OUT17/ 46694

Jemalong Solar (SSD 8803)
Comment on the Environmental Impact Statement (EIS)

Alex King
A/Director, Planning Policy & Assessment Advice
20 December 2017

Figure 8-4 Development extents and 1978 Guideline Levees (purple) and FMP approved levee (light blue)

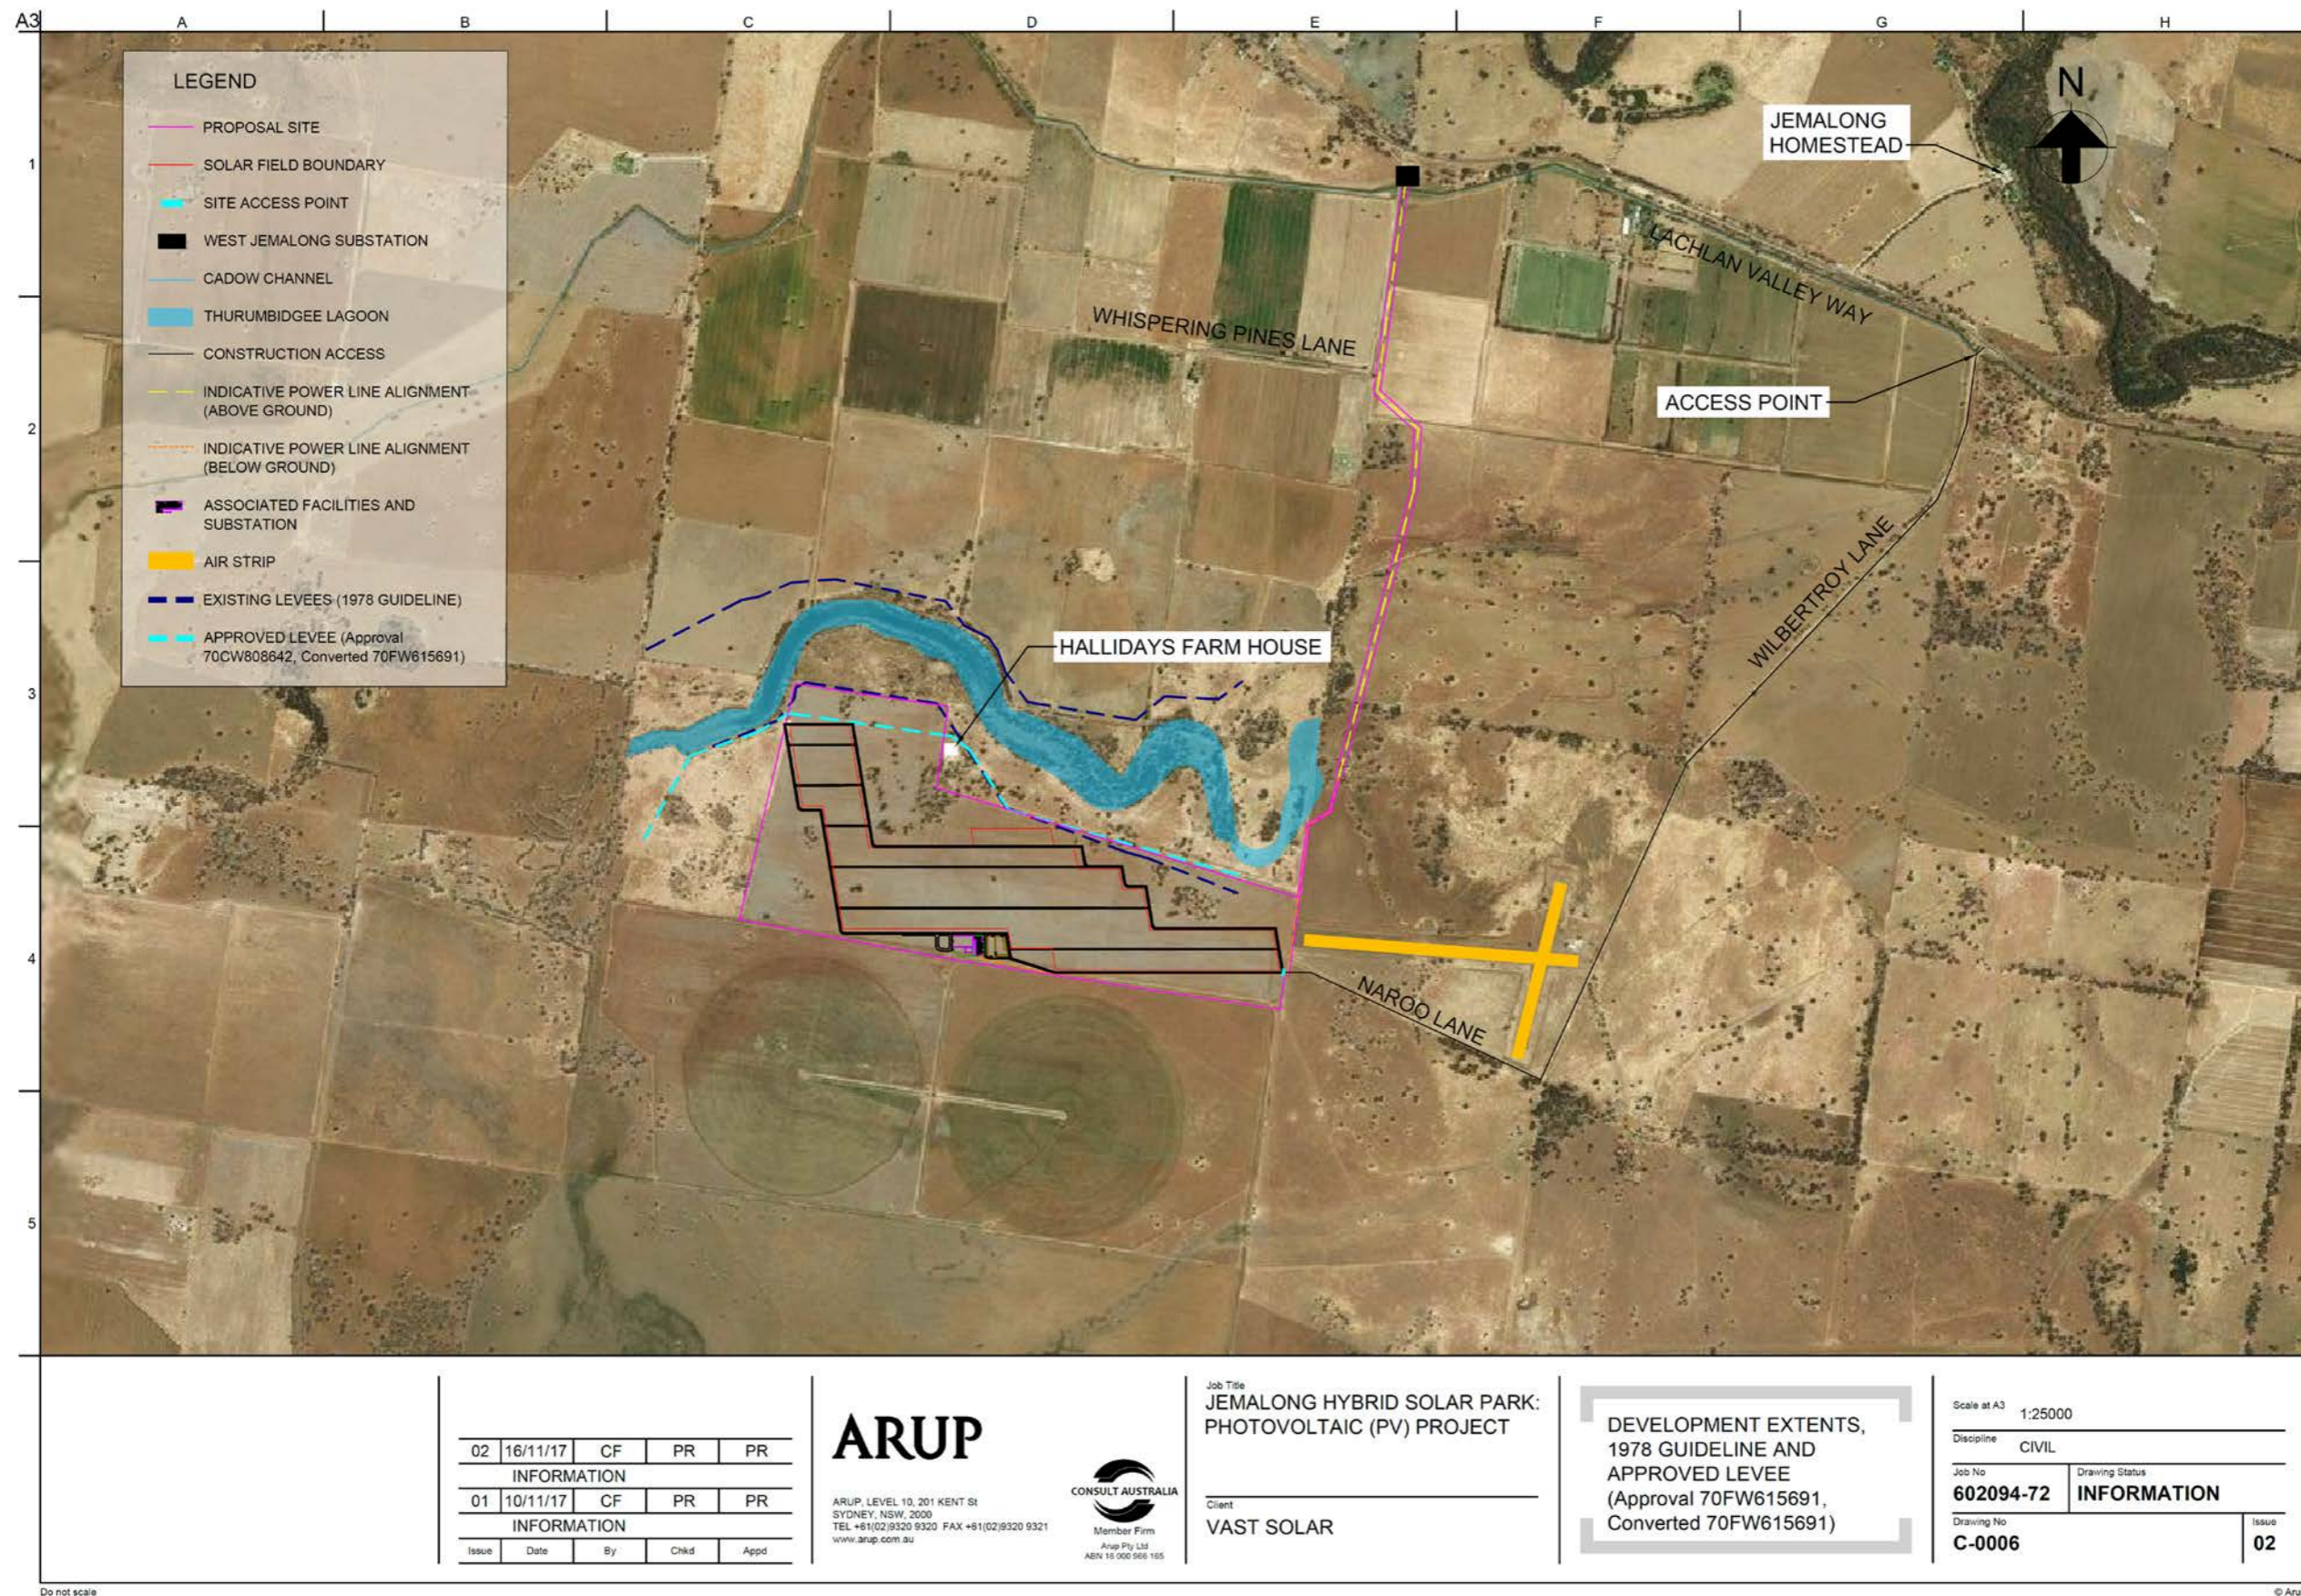
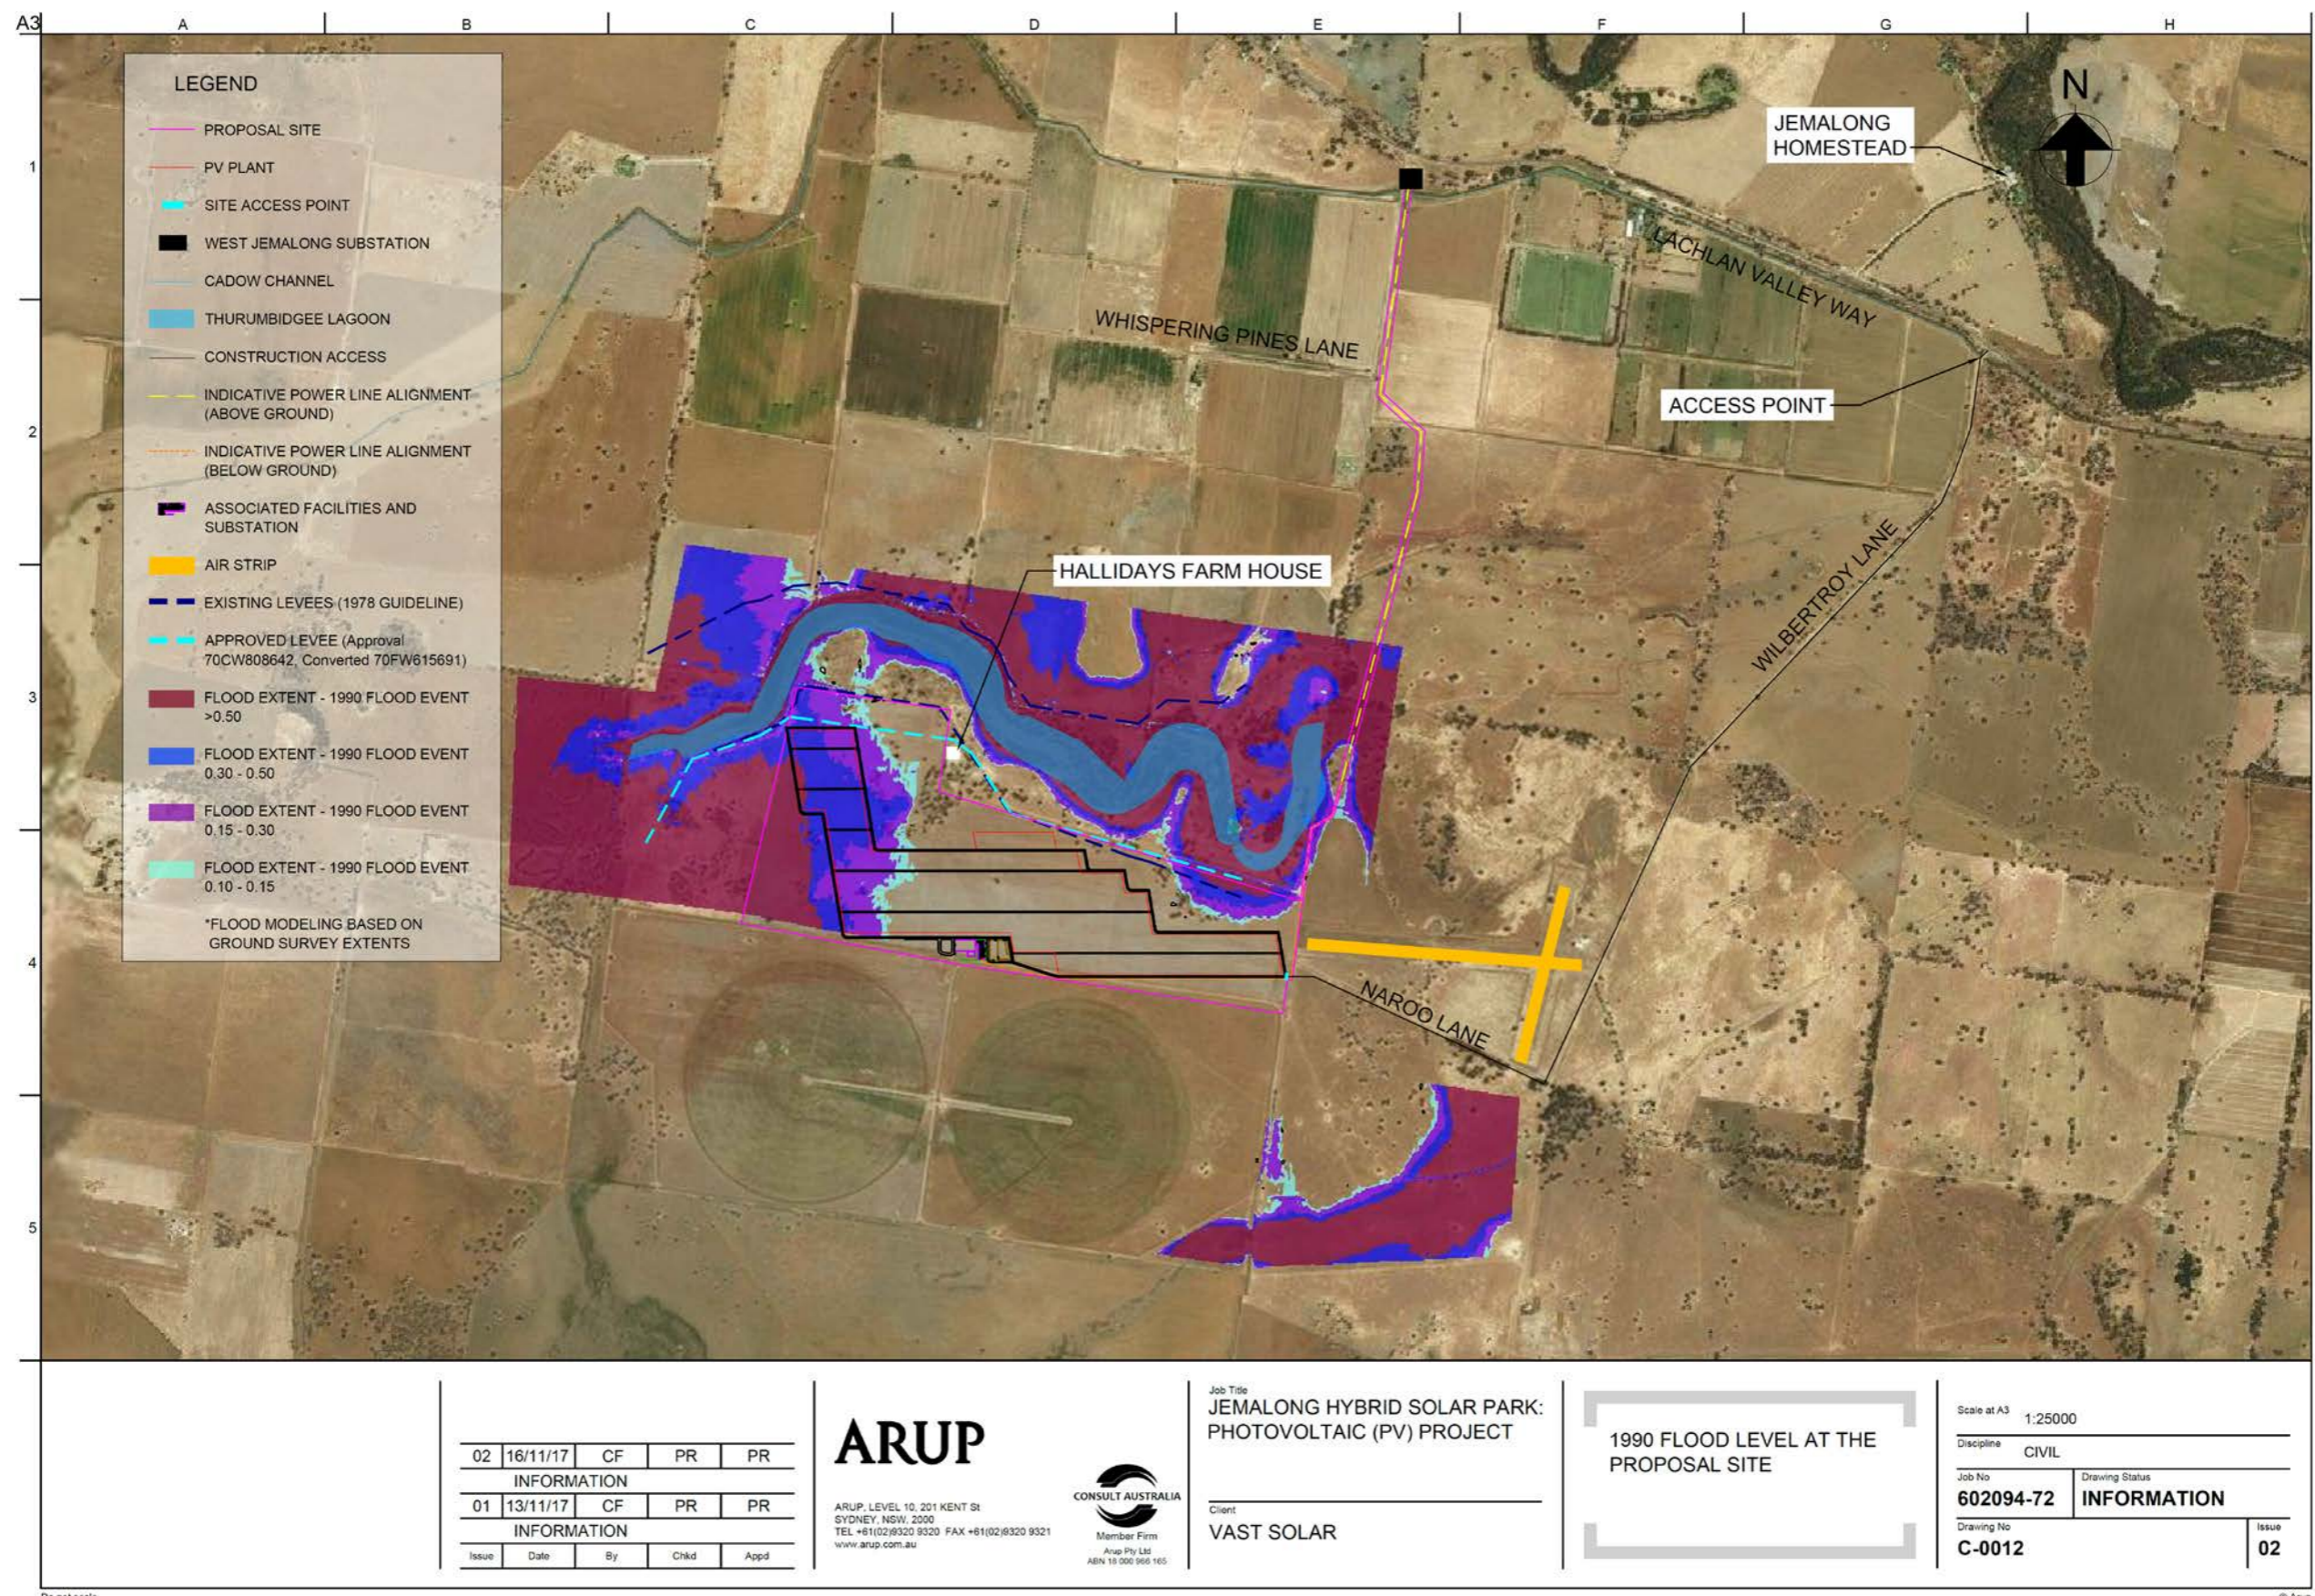
- The proponent should confirm an agreement to access the necessary water supplies and volumes.
- The proponent should provide further flood assessment to confirm the impacts of internal and external road infrastructure, and PV infrastructure installation at the site on the flood characteristics. This assessment should consider the requirements of the Floodplain Management Plan: Lachlan River: Jemalong Gap to Condobolin.
